ST MARYS FREIGHT HUB

FORRESTER ROAD: ACCESS DRIVEWAY TO GLOSSOP STREET ROAD SAFETY AUDIT

FOR
PACIFIC NATIONAL

Figure 2: Access Road Driveway Paths (Source: BG&E)

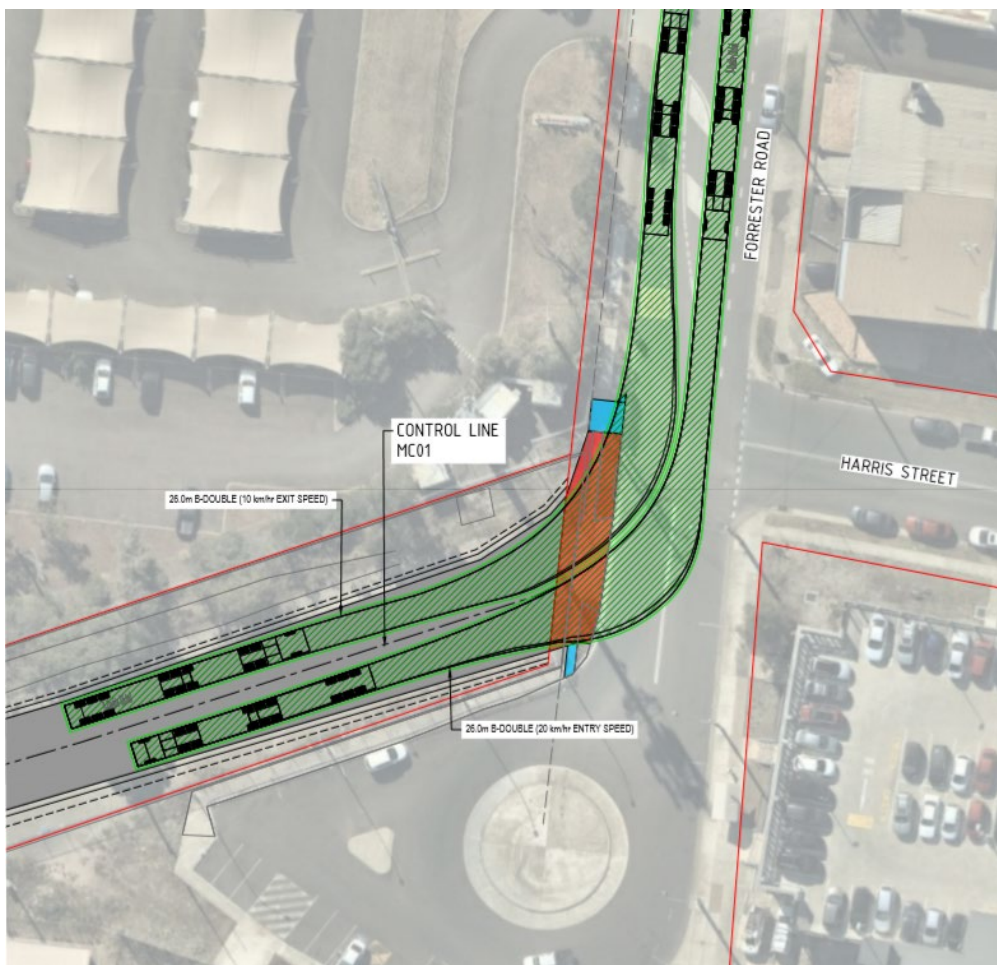
Item	Issue	Risk	Site Illustration	Response on behalf of Pacific National
2	<p>There is a potential sight distance issue for exiting heavy vehicles viewing traffic circulating on the roundabout. Some fencing may require removal or replacement with a more suitable type.</p> <p>The red lines in the second image show the sections of fence that would require modification or removal to meet sight line requirements.</p>	M	 	<p>As part of detailed design development considerations fencing will be removed and/or replaced with a more suitable type and style to preserve sight line integrity.</p>

Figure 3: Proposed signage and access point widening for St Marys Freight Hub (Source: BG&E)

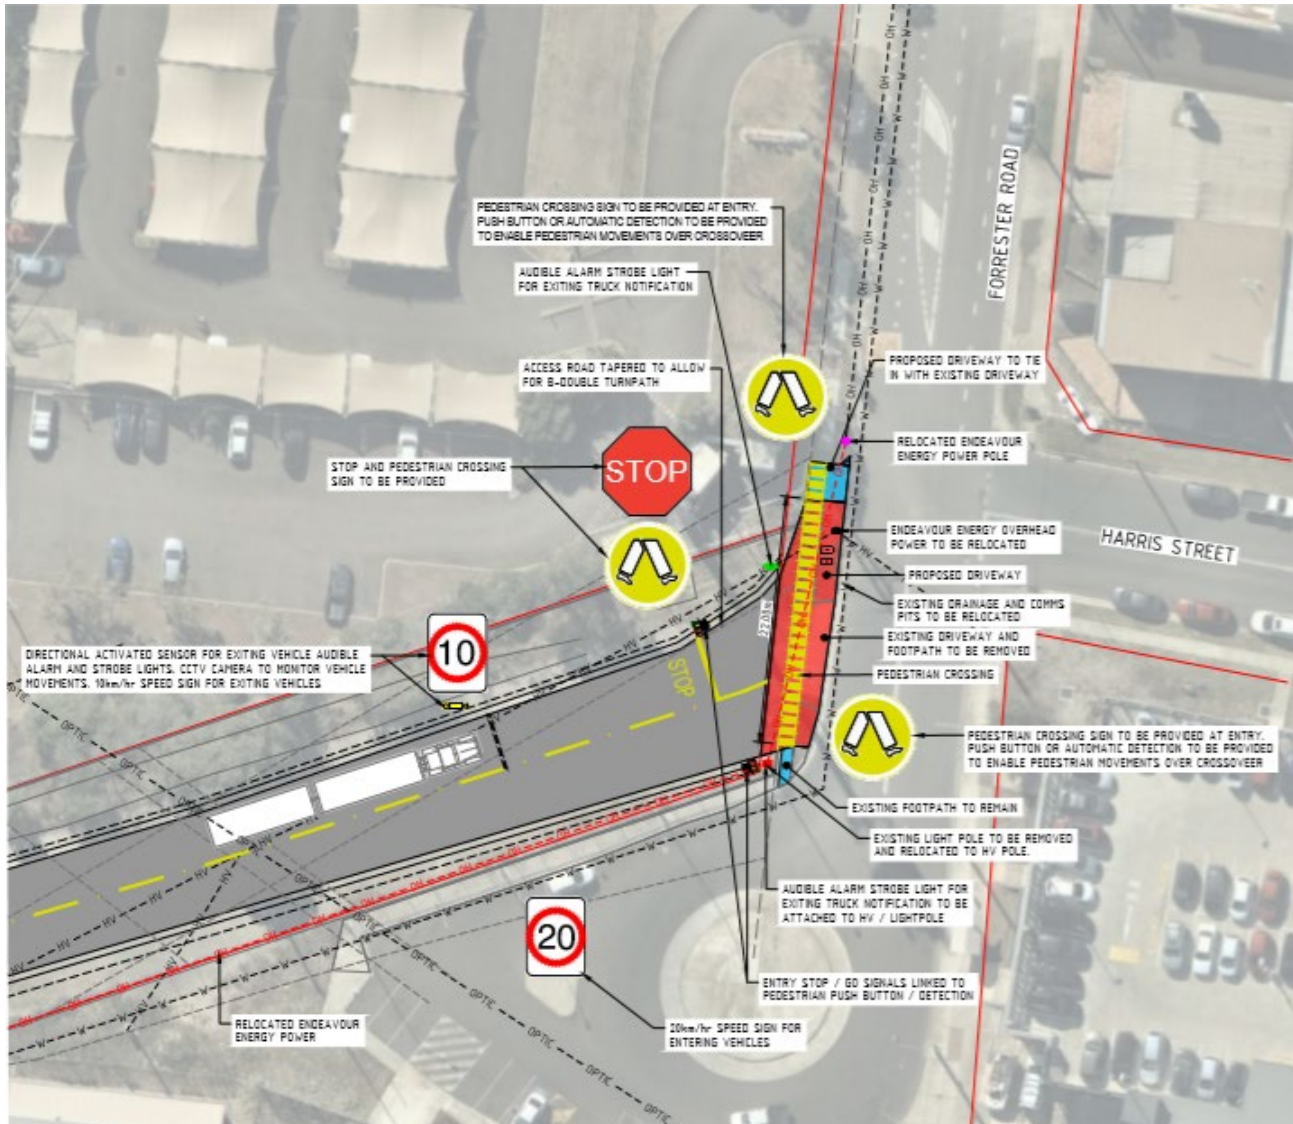
Item	Issue	Risk	Site Illustration	Response on behalf of Pacific National
3	There could be potential confusion over an incoming heavy vehicle's right turn indicator. It might be interpreted by nearby road users as intention to circulate around the roundabout. The likelihood of this risk is low due to low traffic volumes and the consequences are also low due to the slow speed environment and the slow speed of B-Doubles making this turn.	L	(Not applicable)	Noted that this is considered very low risk due to low speed environment and low traffic volumes.
4	As shown in the swept path diagram, the driveway would need to be very wide if an incoming and outgoing B-double were to operate simultaneously. The power pole immediately north of the driveway would require relocation in order to allow the driveway to be widened. This pole carries High Voltage cables.	Note		Refer to "Heavy Vehicle and Transport Analysis Summary Report" at which a concept design is provided in response to this concern.
